The comments of the **Arun District Conservation Area Advisory Panel** are as follows:

Application No: AB/65/22/PL
Registered: 8th June 2022
Site Address: Arundel Cathedral London Road Arundel BN18 9AY
Grid Reference: 501526 107182
Description of Works: Installation of refurbished lighting columns to light western section of churchyard. This application affects the setting of listed buildings and is in the Arundel Conservation Area. This site is in CIL Zone 3 (Zero Rated) as other development.

Arundel Cathedral	
Proposed new lighting columns	
West Elevation as Proposed & lighting detail

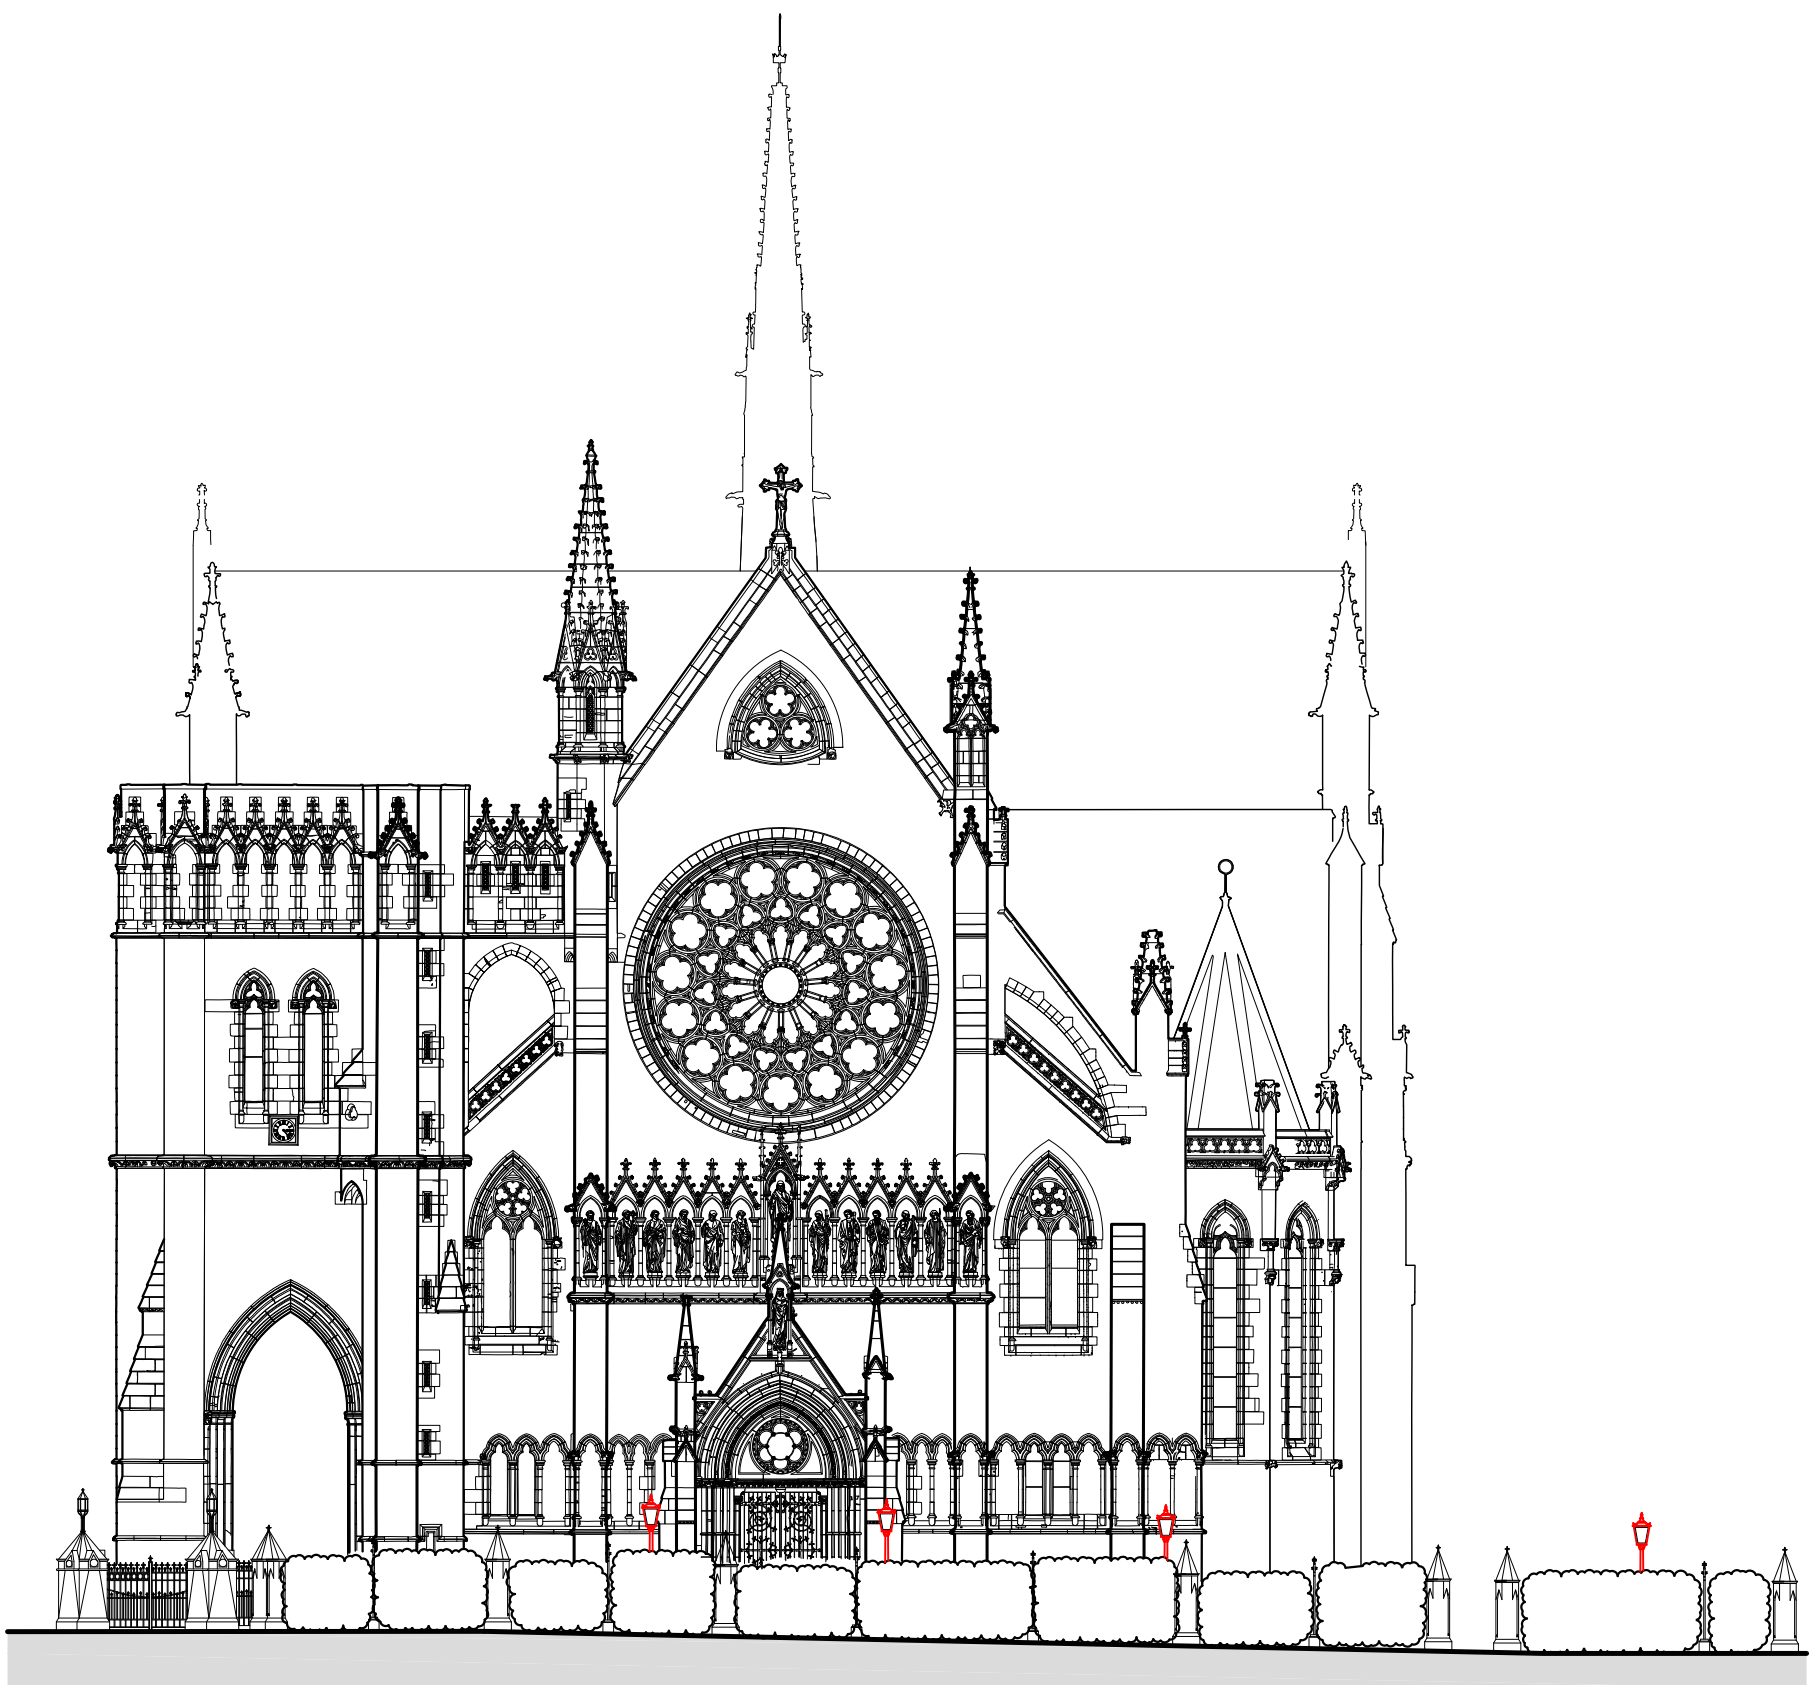
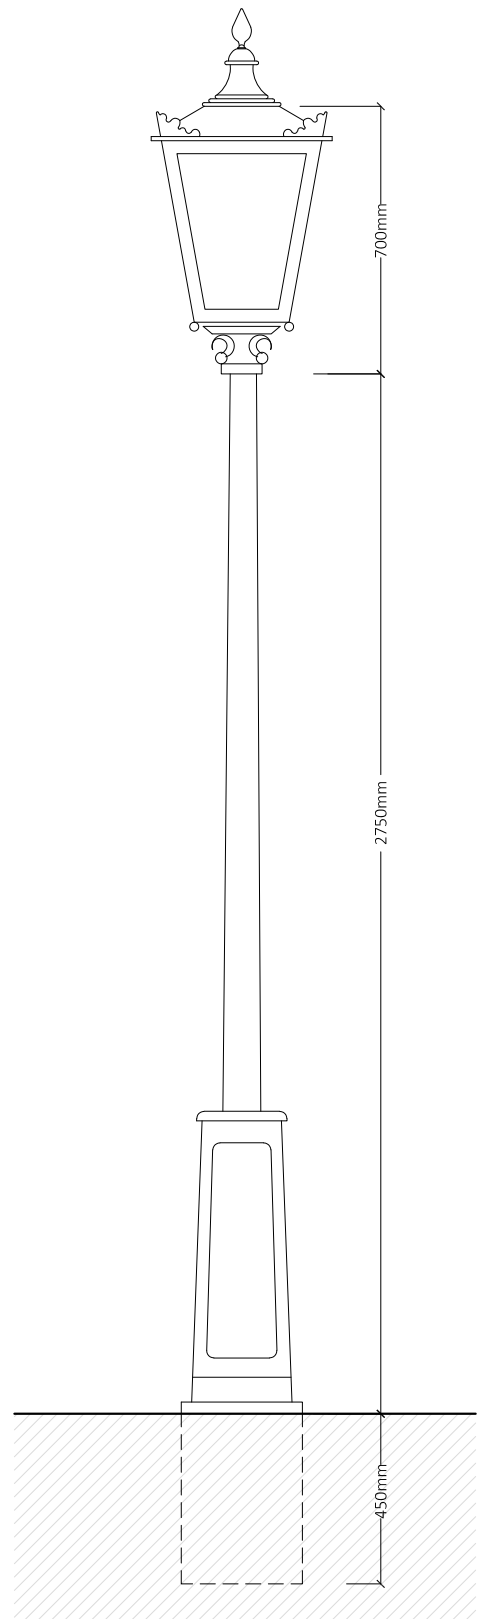
The columns and lamps are of a suitable scale and design in relation to the Cathedral and the streetscene. They are reflective of the existing black painted cast iron public street lighting in London Road and other principal streets in Arundel town centre.

It is considered that the proposals will have no adverse impact on the character or appearance of the conservation area.
